Cc: Juan Baeza <Juan.Baeza@arun.gov.uk>; Conservation Officer <Conservation.Officer@arun.gov.uk>
Subject: LY/13/19/HH

This email is regarding application LY/13/19/HH.

FIG A.

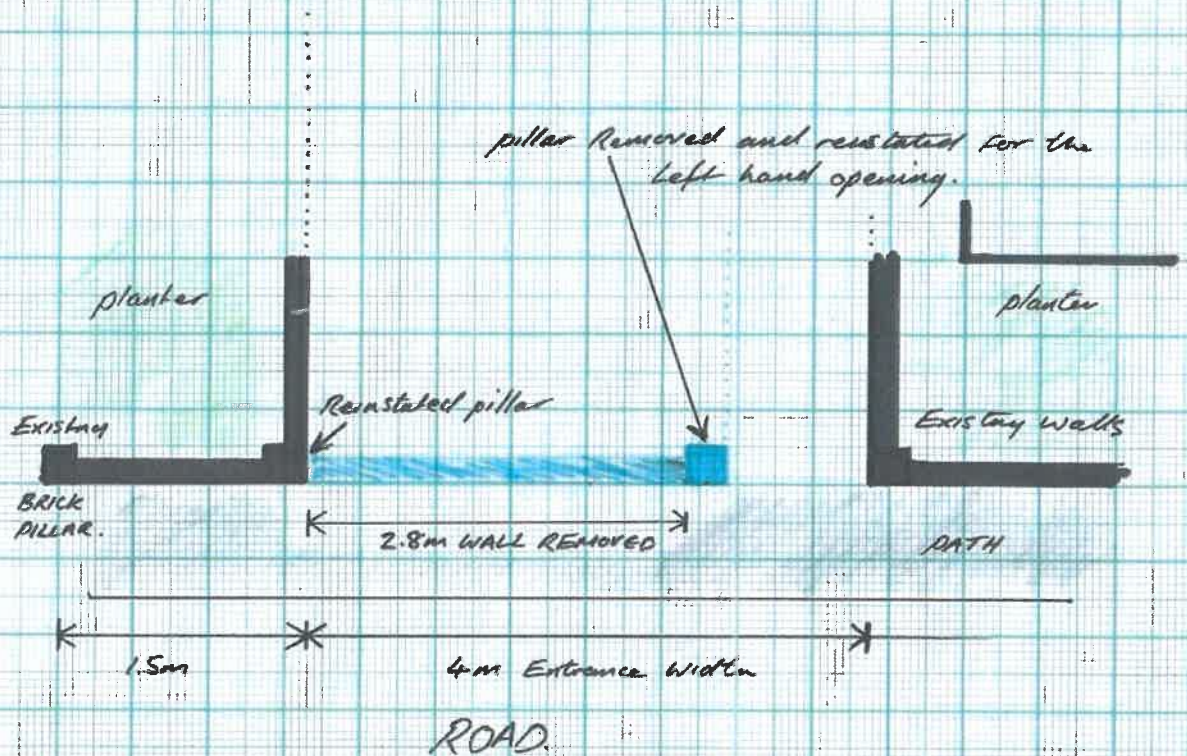
The front boundary wall is one of the most important aspects of the Listed Building, as it is the most visible element of the proposal from the public realm. It is noted that the Conservation Officer finds the proposed removal of the wall (approximately half) to be the absolute maximum allowable loss, without causing detrimental harm to the Conservation Area. I agree with this.

West Sussex County Councils Highways department have *essentially* object to the scheme in its current form on safety grounds, in that they have asked for additional information and alterations to the scheme. One of these alterations is that the remainder of the boundary wall would need to be lowered by 0.6m. As noted previously, the current reduction proposed under the scheme would already be the maximum permitted without causing undue harm to the area.

As such, the application will be refused on ground of highway safety. Please note that West Sussex County Councils Highways department do propose that a seven-day speed survey could be submitted as supporting evidence to a resubmission. Furthermore, another reason for refusal would be in the unclarity of the plans, and the lack of plans relating to the restoration of the outbuilding. Finally, in the Conservation Officer's comments, they raise further information they would like clarified, which may save these details being asked for via condition, on any potential resubmission.
